# PORTLAND MAINE

**RE:** Review Comments for Final Single Family Plan, 11 Pomeroy Street

Thank you for submitting a Level I: Minor Residential site plan application for your proposed single family residence at 11 Pomeroy Street. This proposal is being reviewed as a final plan and subject to the following applicable Land Use Code provisions:

**TO:** Nell Donaldson, Planner  
**FROM:** David Senus, P.E. & Ashley Auger, E.I.T.  
**DATE:** May 30, 2012  
**RE:** Pomeroy Street Construction, Level I & II Site Plan Application

SHEET
7

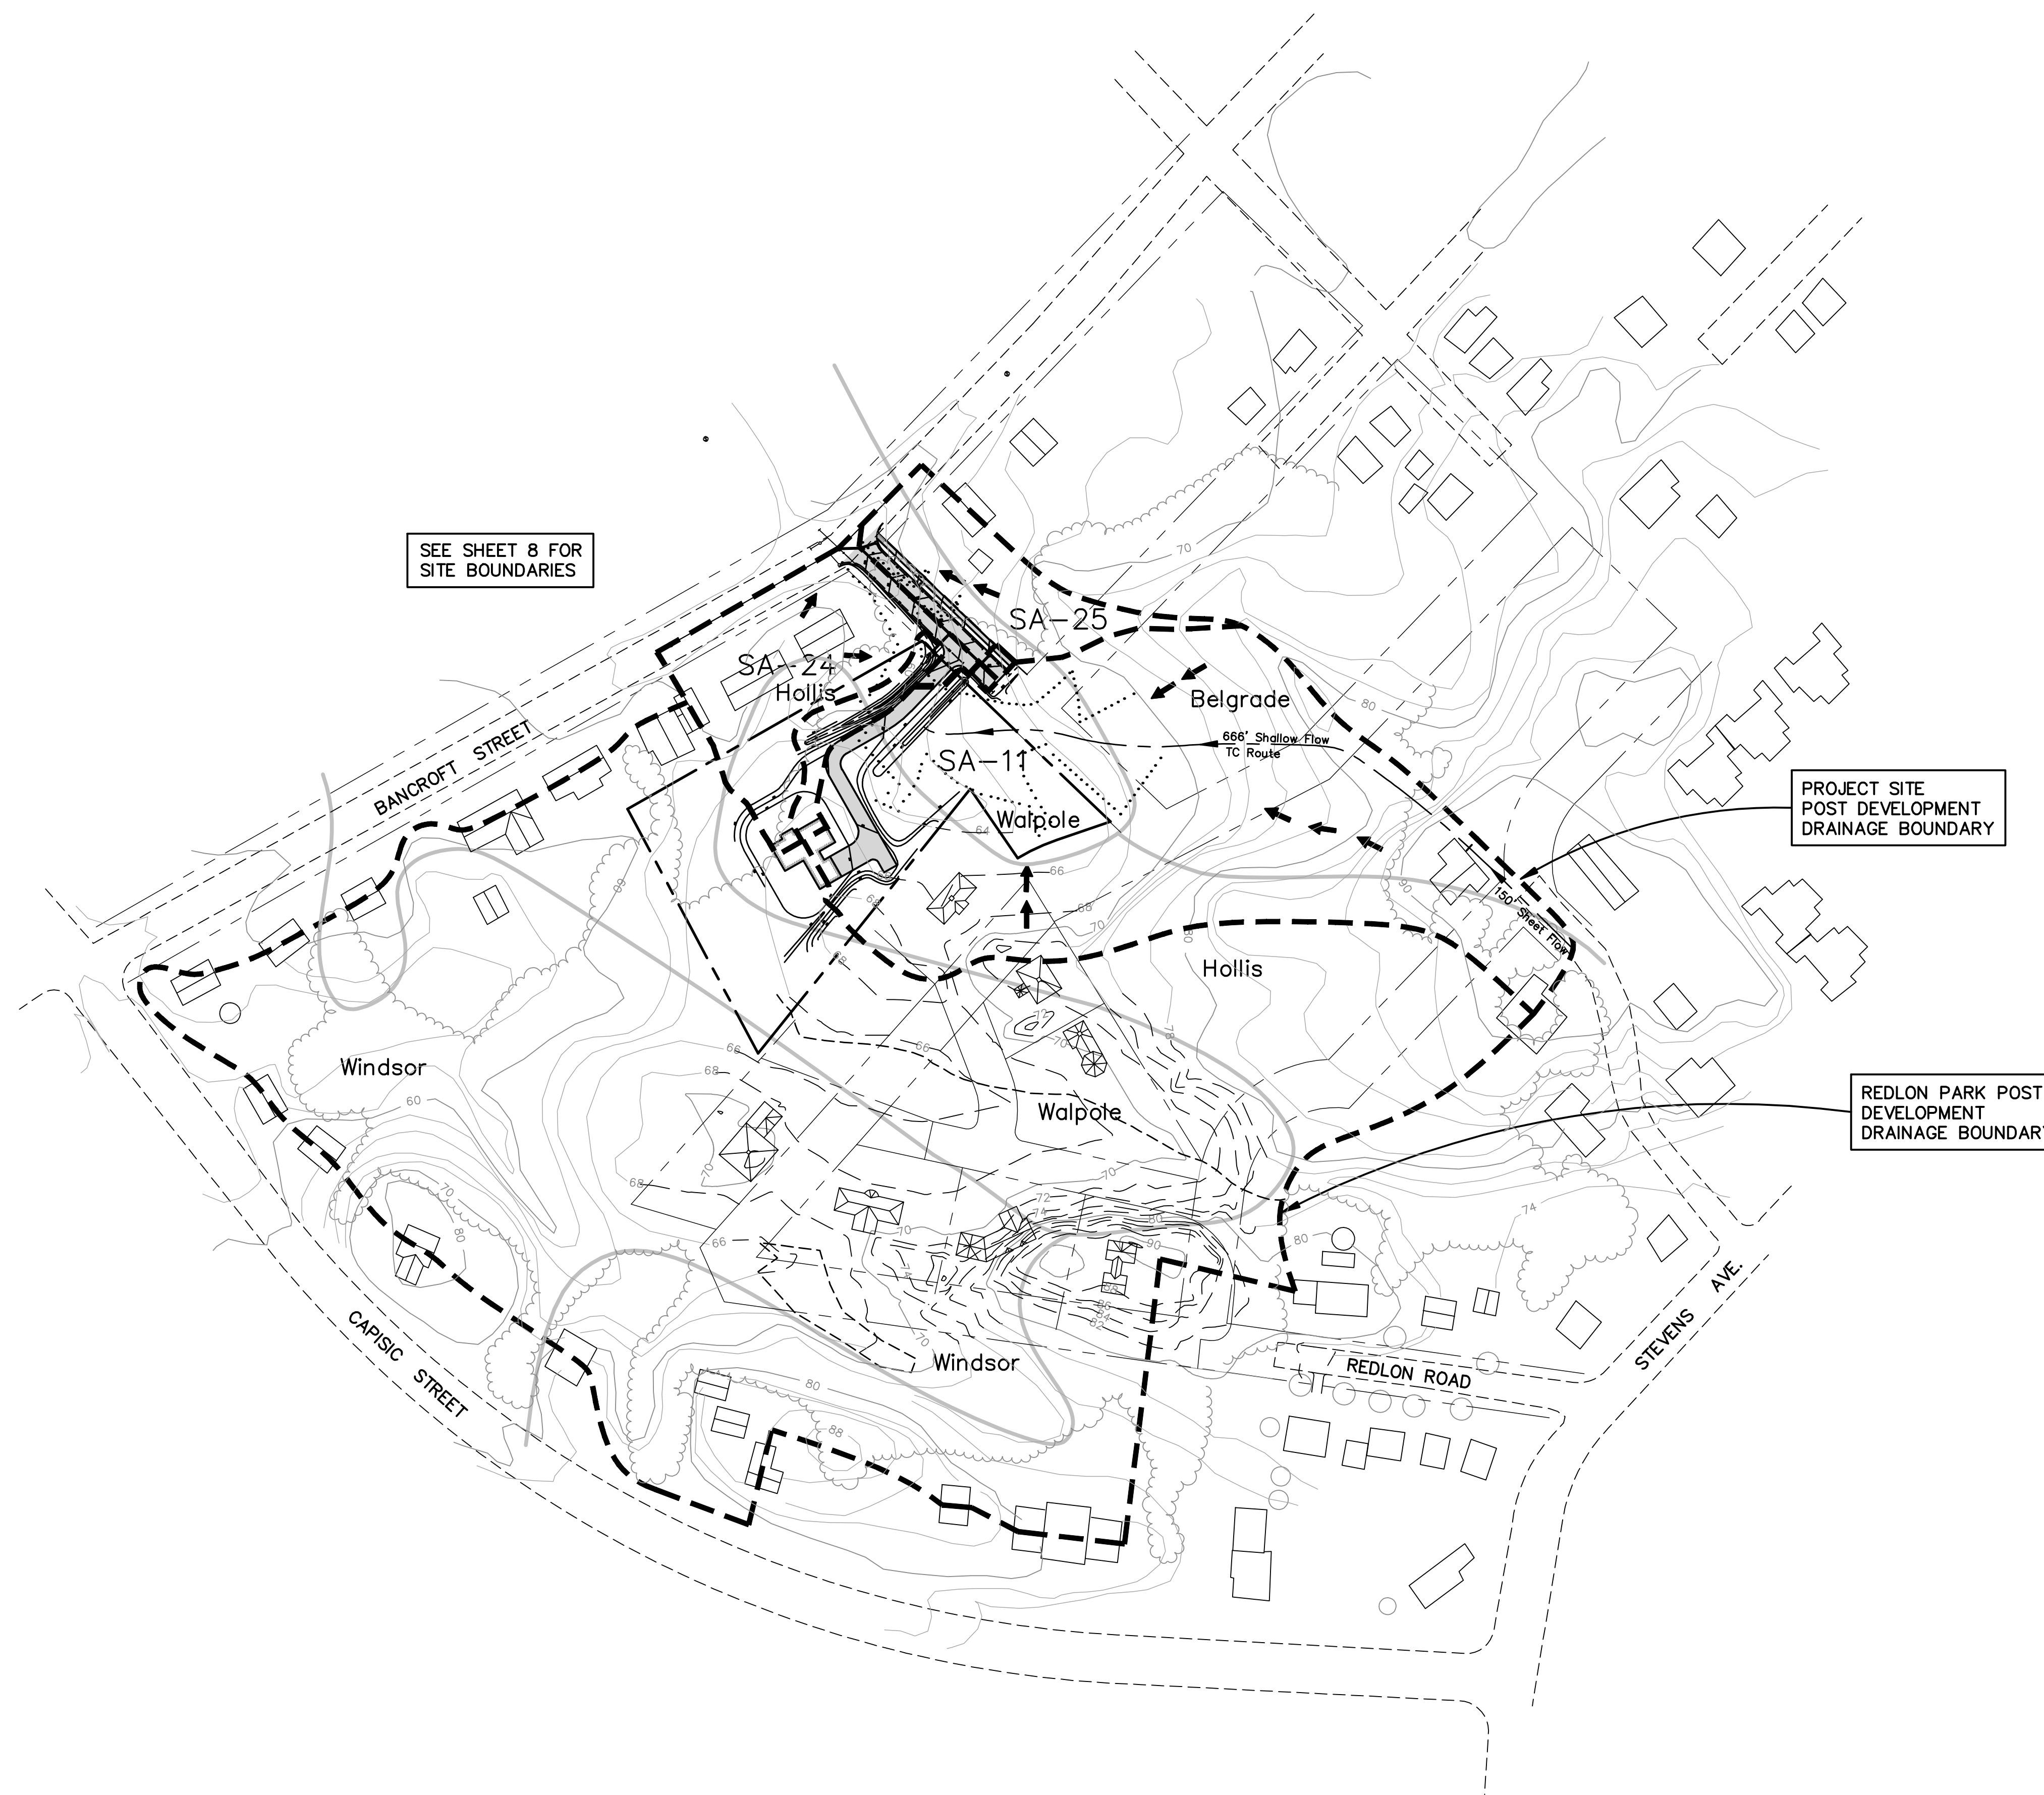
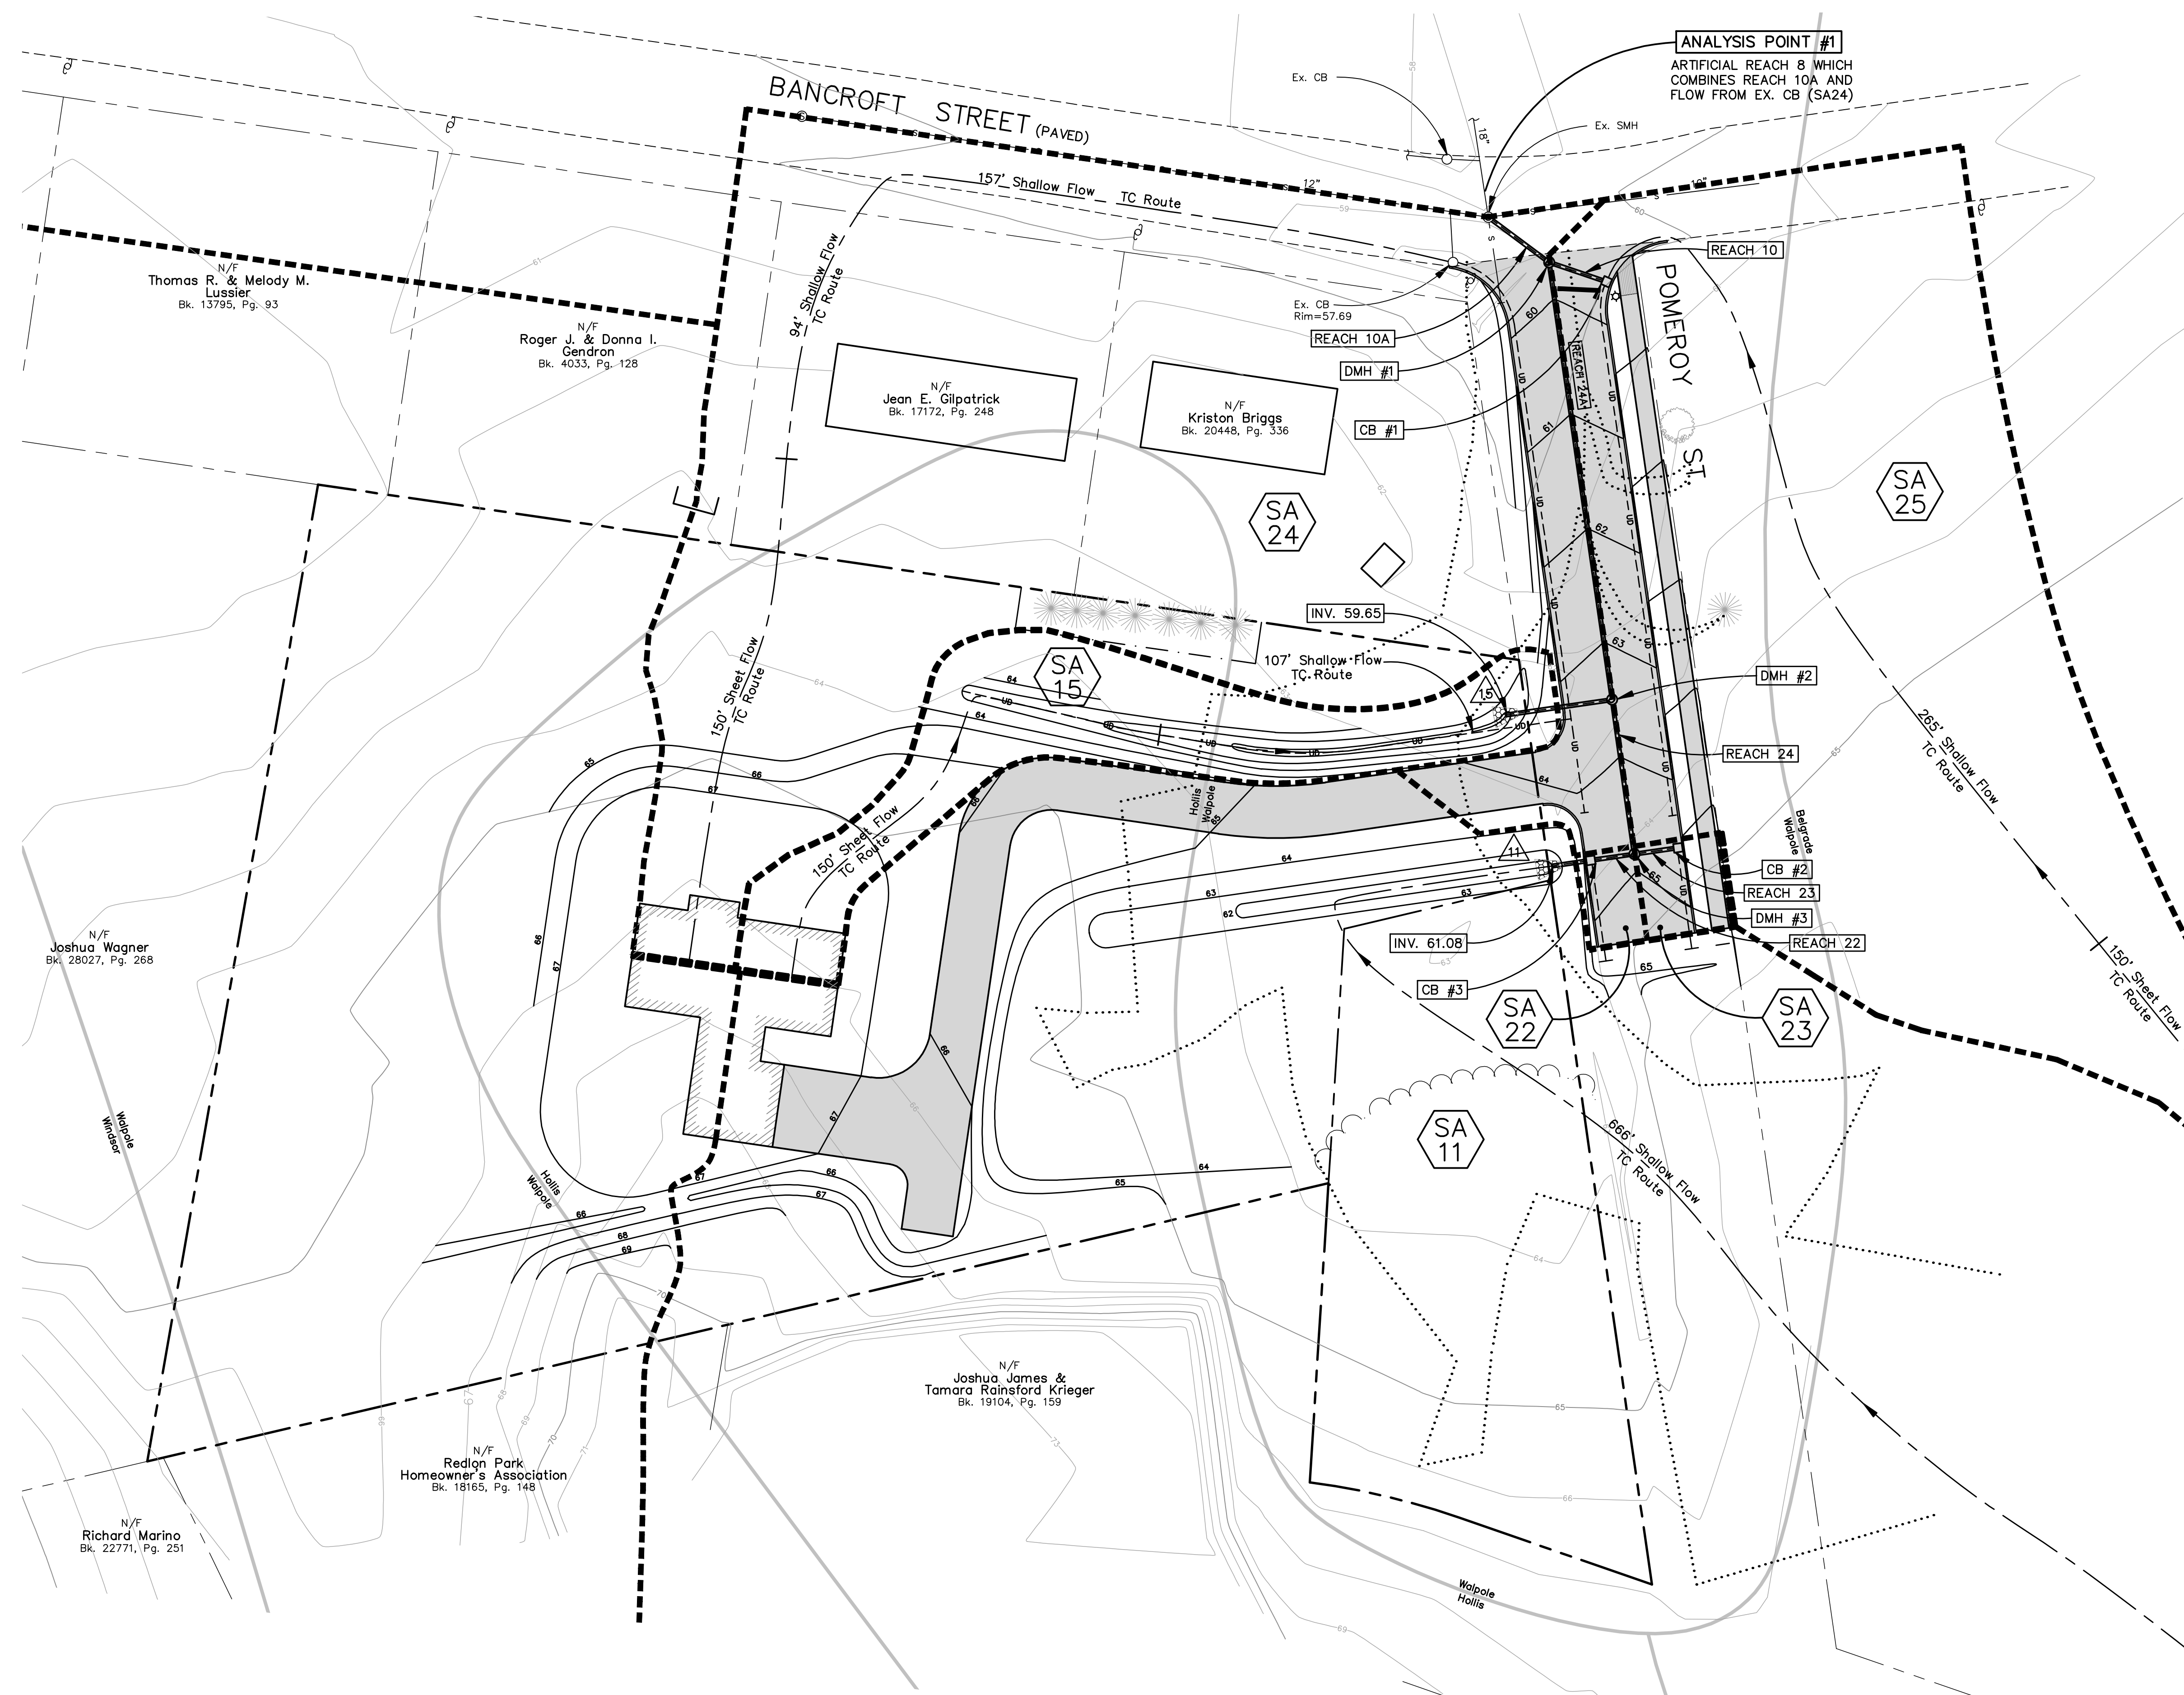
- c) Flooding Standard: The applicant has provided a Stormwater Management Report with a HydroCAD analysis of the 2, 10 and 25 year, 24 hour storm events modeled for the predevelopment and post-development conditions. The runoff analysis indicates that the project will reduce peak flowrates at the project study point, a combined sewer inlet on Bancroft Street. The applicant should address the following

- i) The input parameters for Sheet Flow for SA-1 (Pre) and SA-11 (Post) should be the same, as this area will not change as a result of the project.
